Subject: RE: M/130/21/DOC - 8 Manor Way, PO22 6LA

Our Engineer has looked at the details submitted to date and provided the following comment to the information submitted:

REAR GARDEN GROUND FLOOR TERRACE
CONSTRUCTION PERMEABLE BLOCK PAVING
(Scale 1:20)

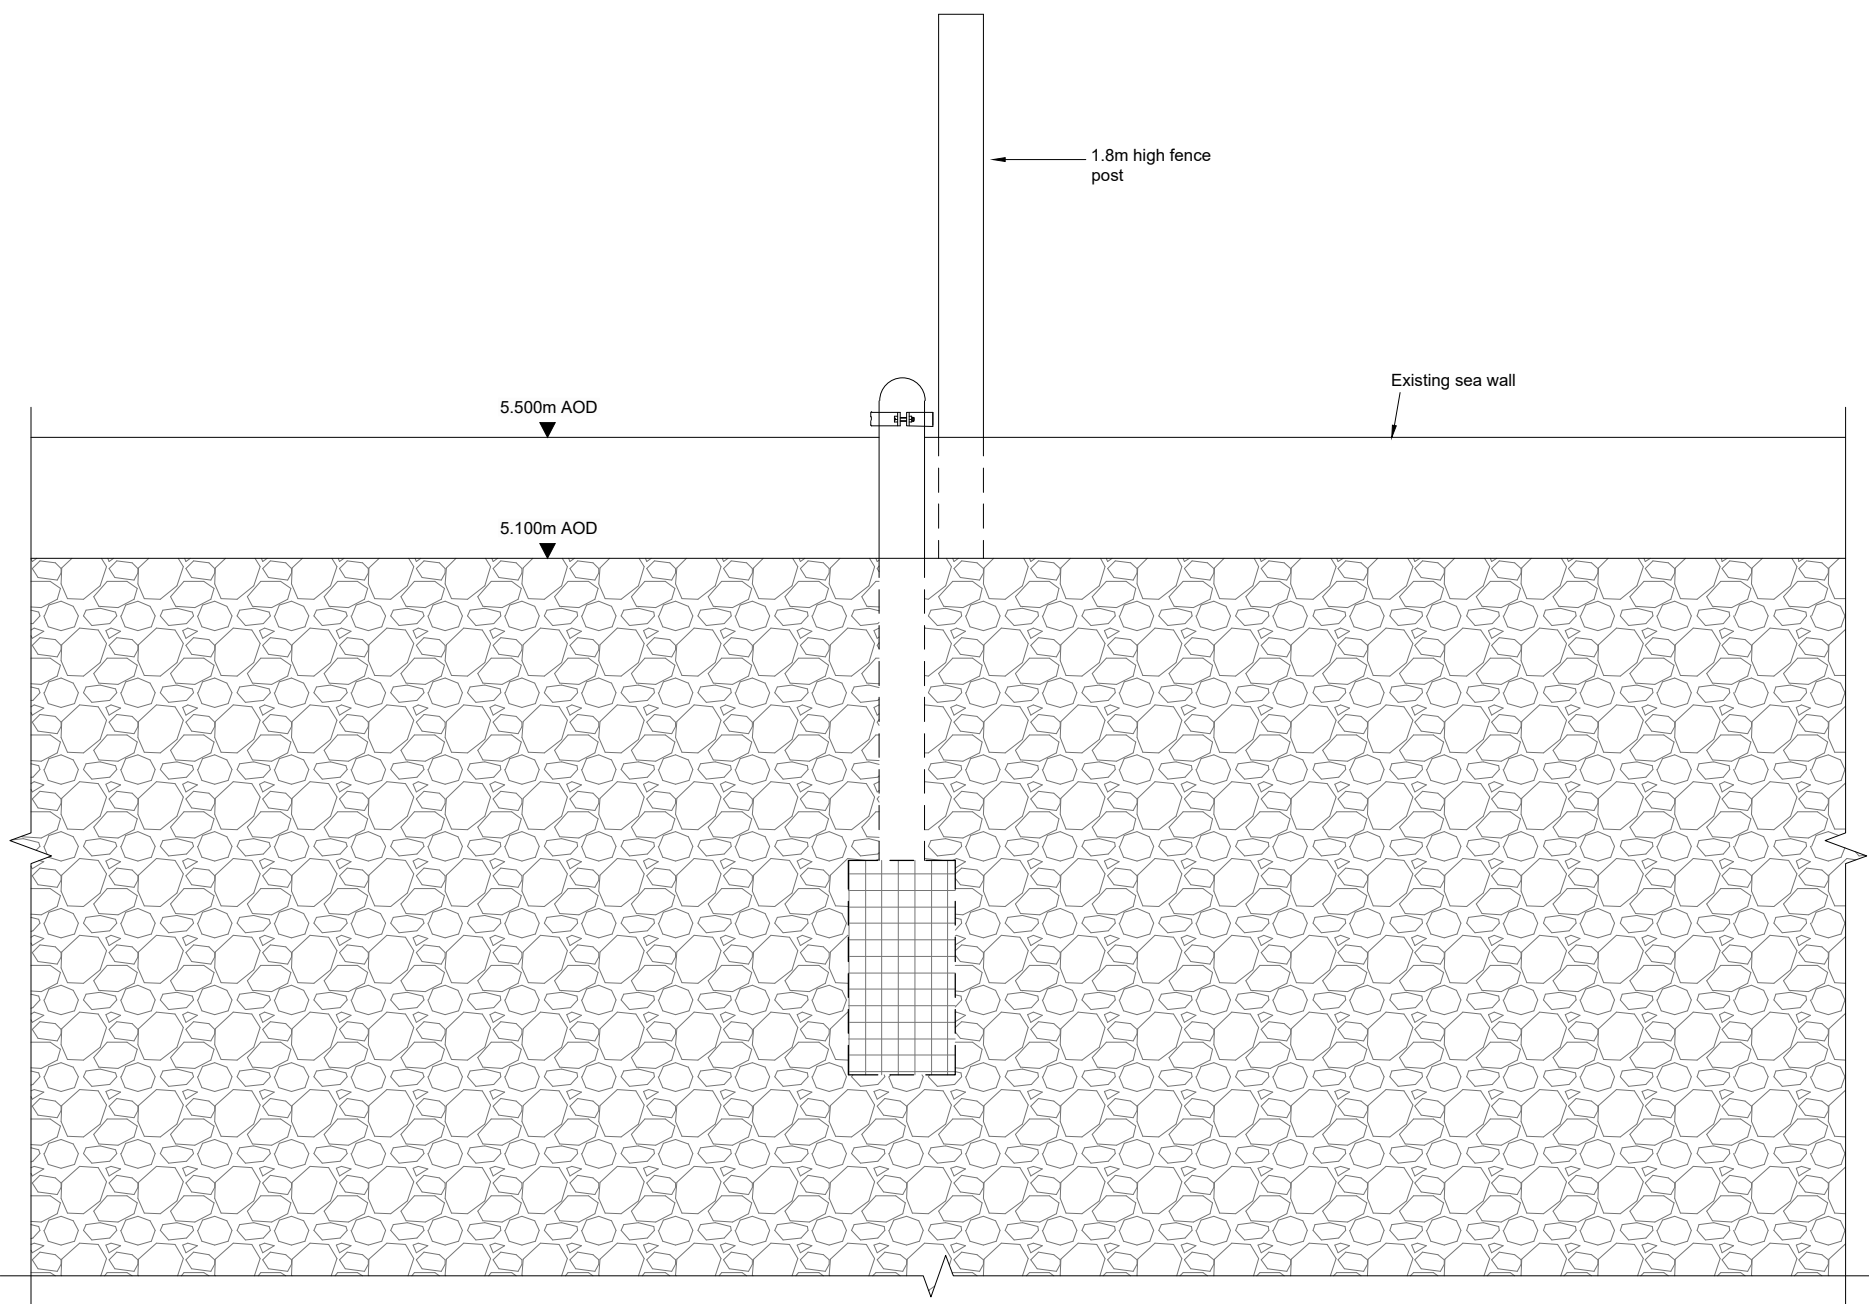
‘Please can an impermeable liner be provided to the sides of the rear garden ground floor terrace to ensure that water does not travel through the sides of this raised area and infiltrates through the bottom only?’
